From: Gregg, Robert <Robert.Gregg@lancashire.gov.uk>
Sent: 06 December 2018 14:01
To: Stephen Kilmartin
Cc: planning; LHS Customer Service
Subject: APP. 3/2018/1066 - ROSE COTTAGE, EDISFORD ROAD, CLITHEROE

Demolition of existing cattery and erection of one new dwelling with separate garage

Proposed Site Layout

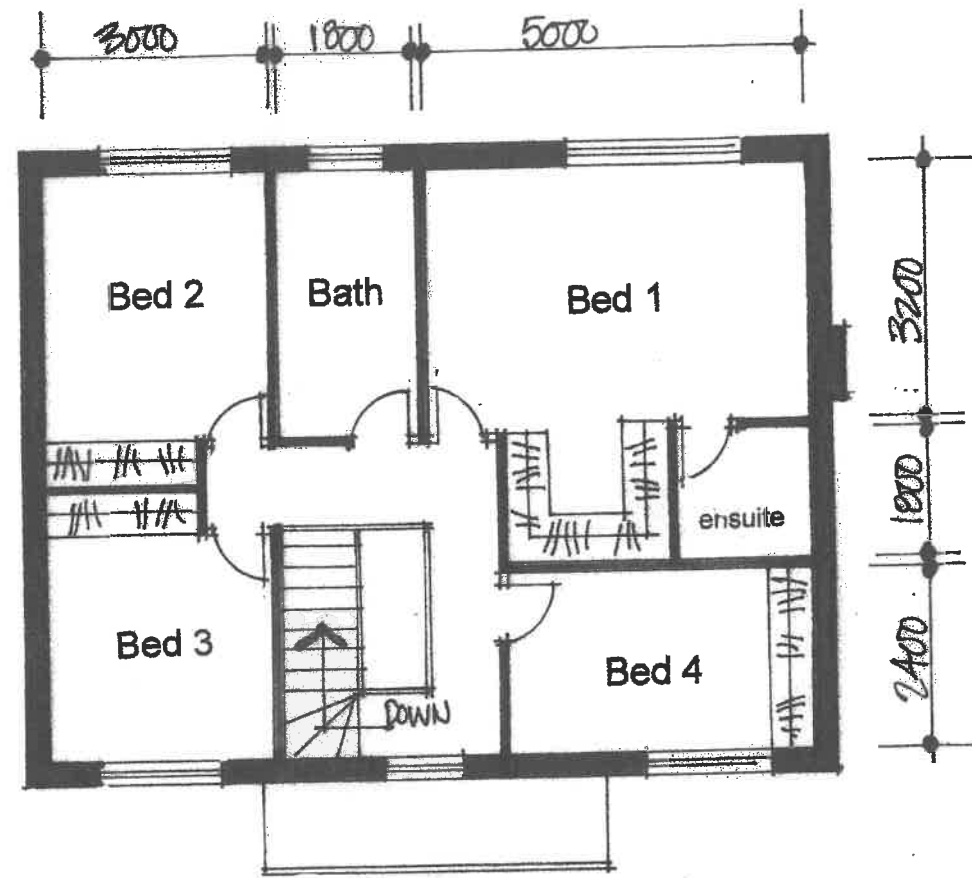
The proposal would result in the demolition of an existing cattery and the erection of a 4 bedroom dwelling with an external double garage, therefore the provision of 3 parking spaces would be sufficient for this proposal.

The proposed new dwelling would be sited on land off a private access lane adjacent to an existing dwelling, the existing dwelling has access to an existing external garage and I would like to note that the proposed new fence would to a certain degree, compromise entry to the existing garage, although there is adequate space for the manoeuvrability of any vehicles using the garage.
